From: Fairchild Fenton, Diane
Sent: 30 April 2020 16:19
To: _planningadvice
Subject: FW: Application reference.: H09-0311-20.

From: Fairchild Fenton, Diane
Sent: 29 April 2020 17:10
To: 'Simon Buttery' <simon.buttery@ground-control.co.uk>
Subject: Application reference.: H09-0311-20.

91/2121 (21E0278)
HOLBEACH ST JOHNS

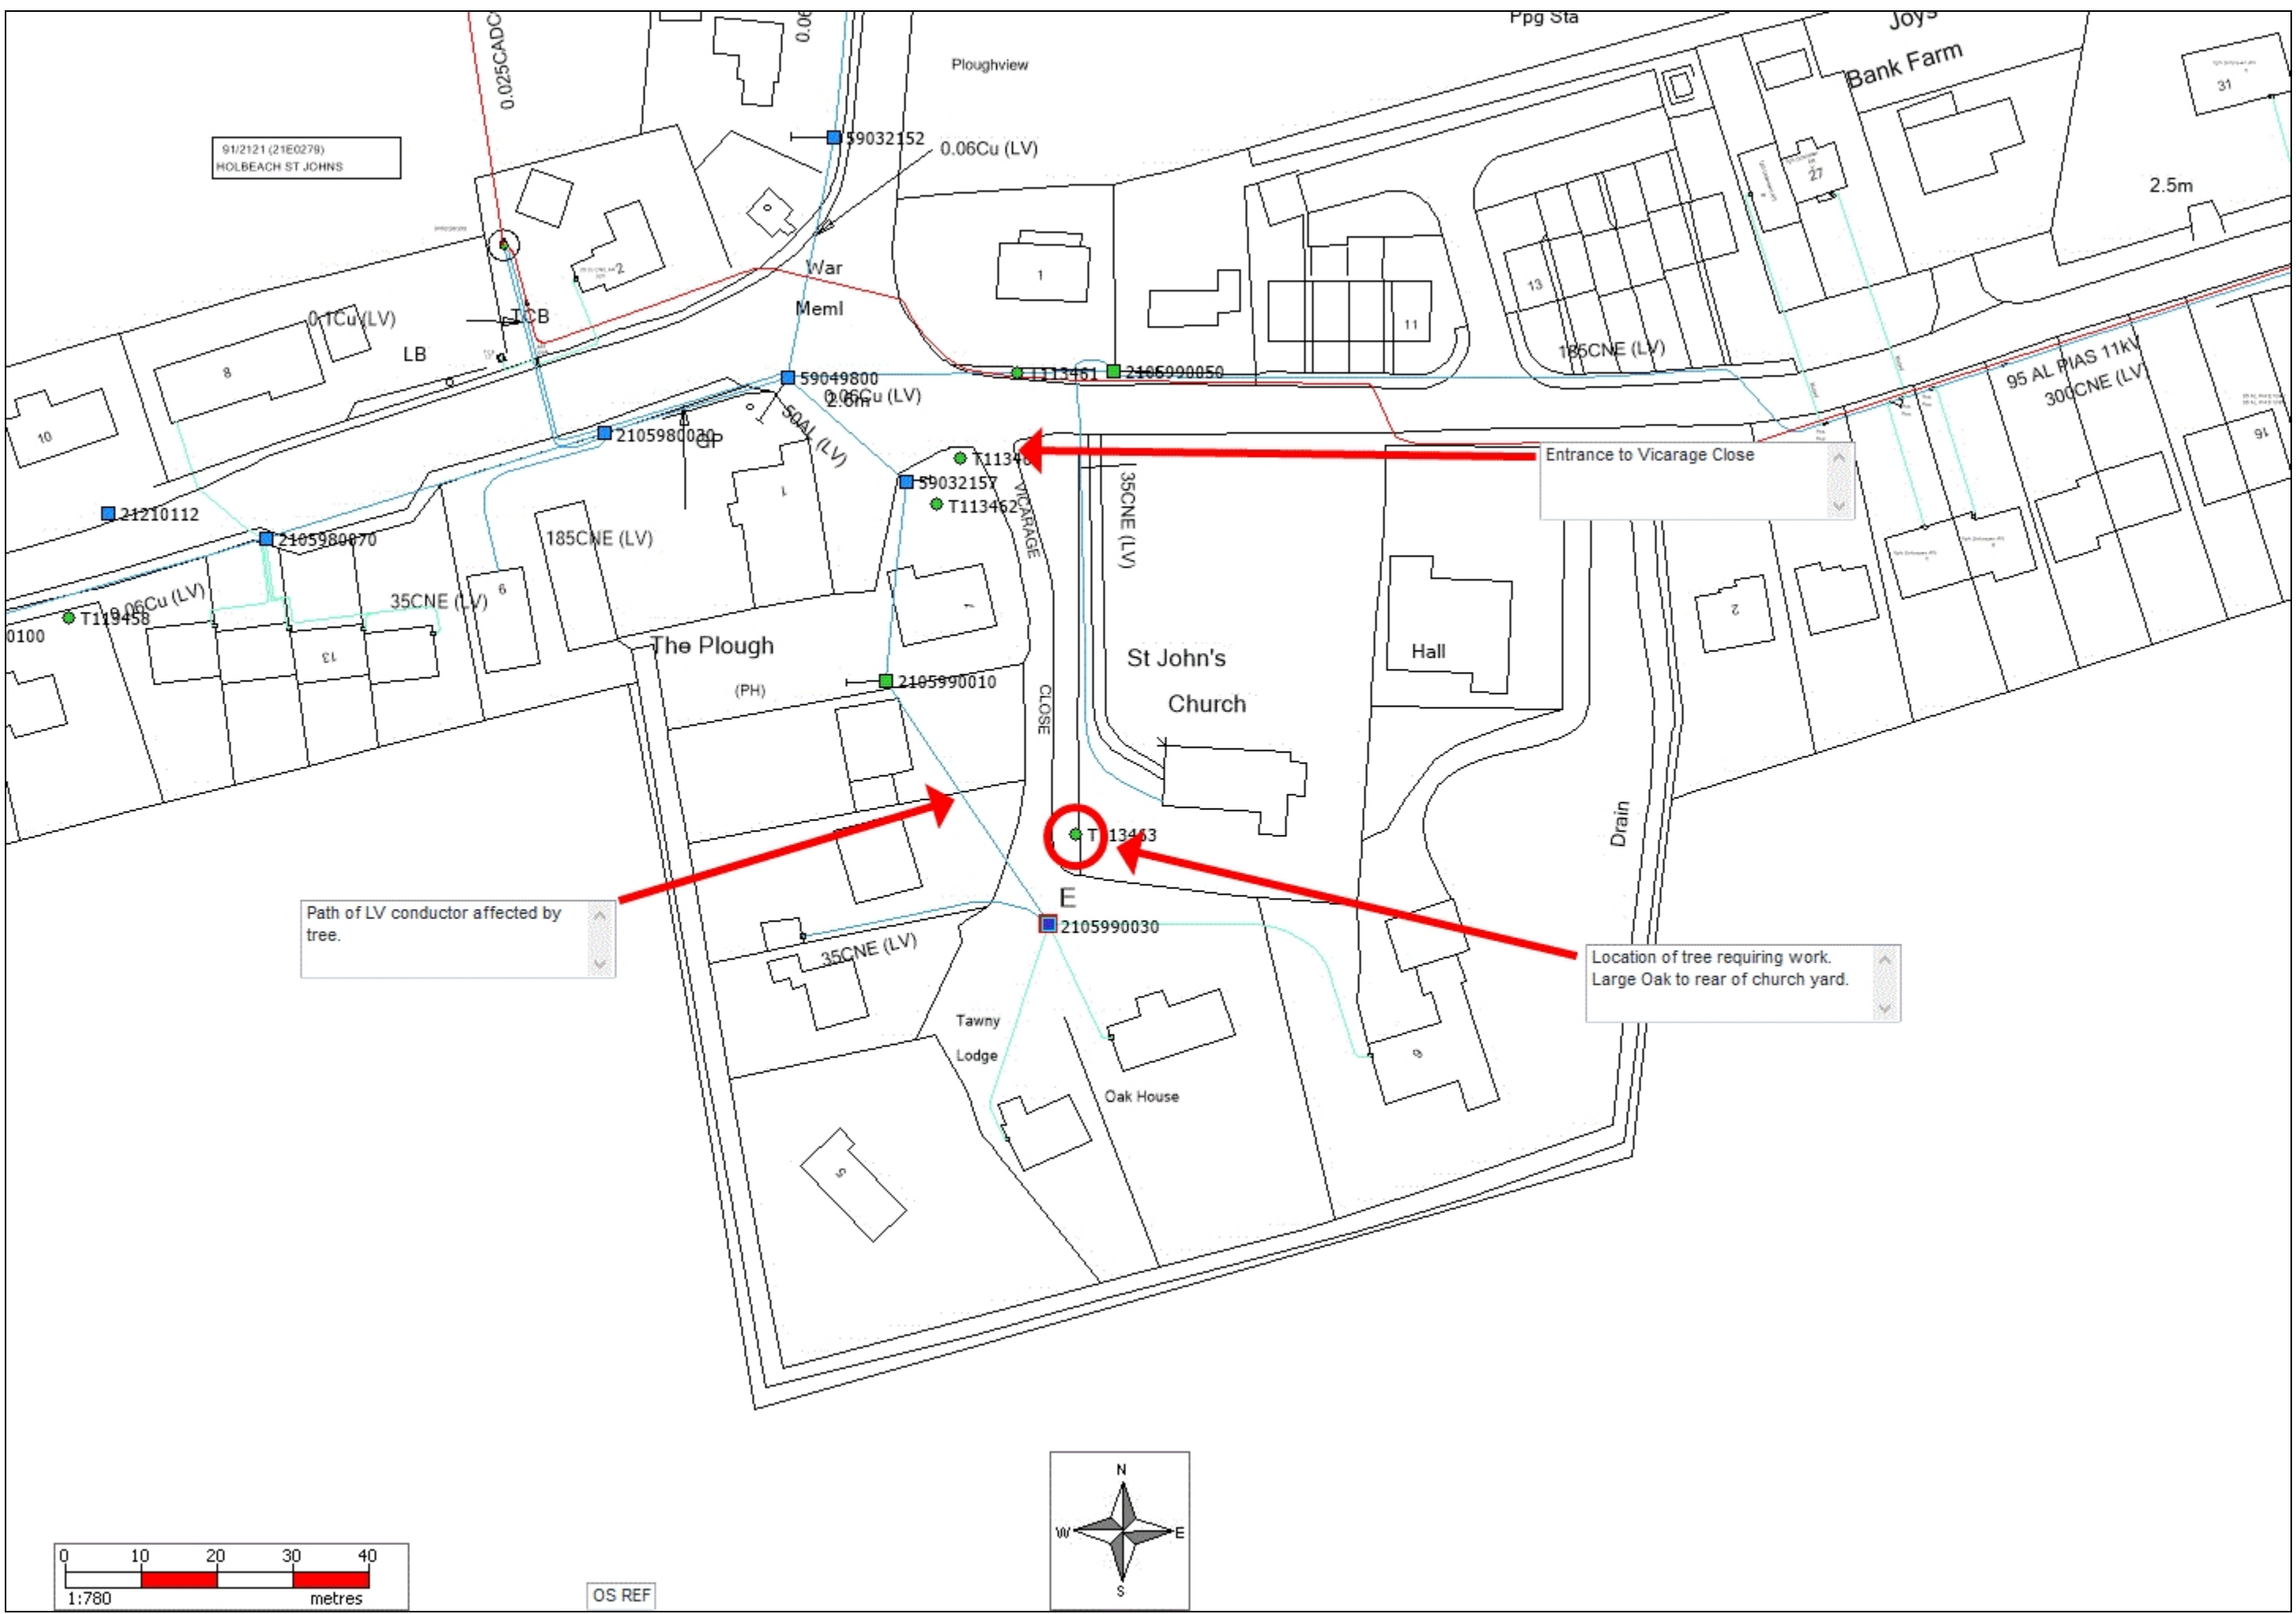
'Two limbs require removal from large Oak tree (highlighted on map and pictures) these limbs are within the live zone of an open wire conductor.

ENATS requires a 3 metre clearance for climbable trees to be around this live zone for safety reasons, these limbs are well within that limit, limbs within this proximity could potentially be live due to their location. All work would be done by qualified arborists who are utility arb trained and under shutdown conditions due to the danger of cutting so close to the conductor live work is not possible.'

Side Prune - Circles on drawing identify limbs not where to make cuts, clearances based on council guidelines TPO tree.

SPECIAL INSTRUCTIONS TPO TREE MINIMAL AS POSSIBLE CUTS TO PREVENT MAJOR WOUNDS ON TREE. CLEARANCE OF 1.5 METRE AROUND CONDUCTOR WITH TREE GUARD FITTED TO INSULATE LINE AFTER COMPLETION OF WORK. Advanced notice needs to be given
